NorthConnex Application Number: SSI 13_6136

Please find following my submission letter in relation to the exhibition of the EIS for the NorthConnex project.

Longitudinal Section: Proposed M1-M2 Tunnel + Extension

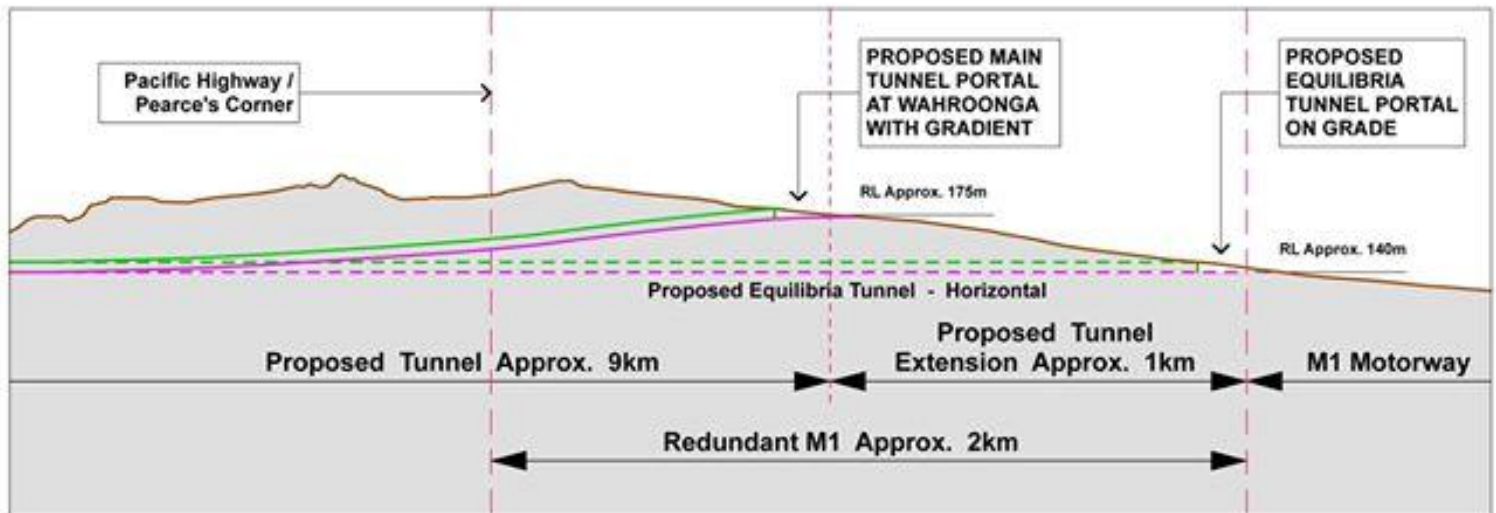
- Extension of the tunnel by a mere 1.5km north into the industrial area near Asquith (in line with Stokes Avenue) and venting the emissions into the national park. I understand that an example of this was presented in the 'Equilibria' proposal.
Extension of the tunnel presents numerous benefits, including:

- The road-tunnel gradient at the northern point would be flatter, thereby reducing emissions.
 - The portal and stack could be located far away from the nearest residential area.
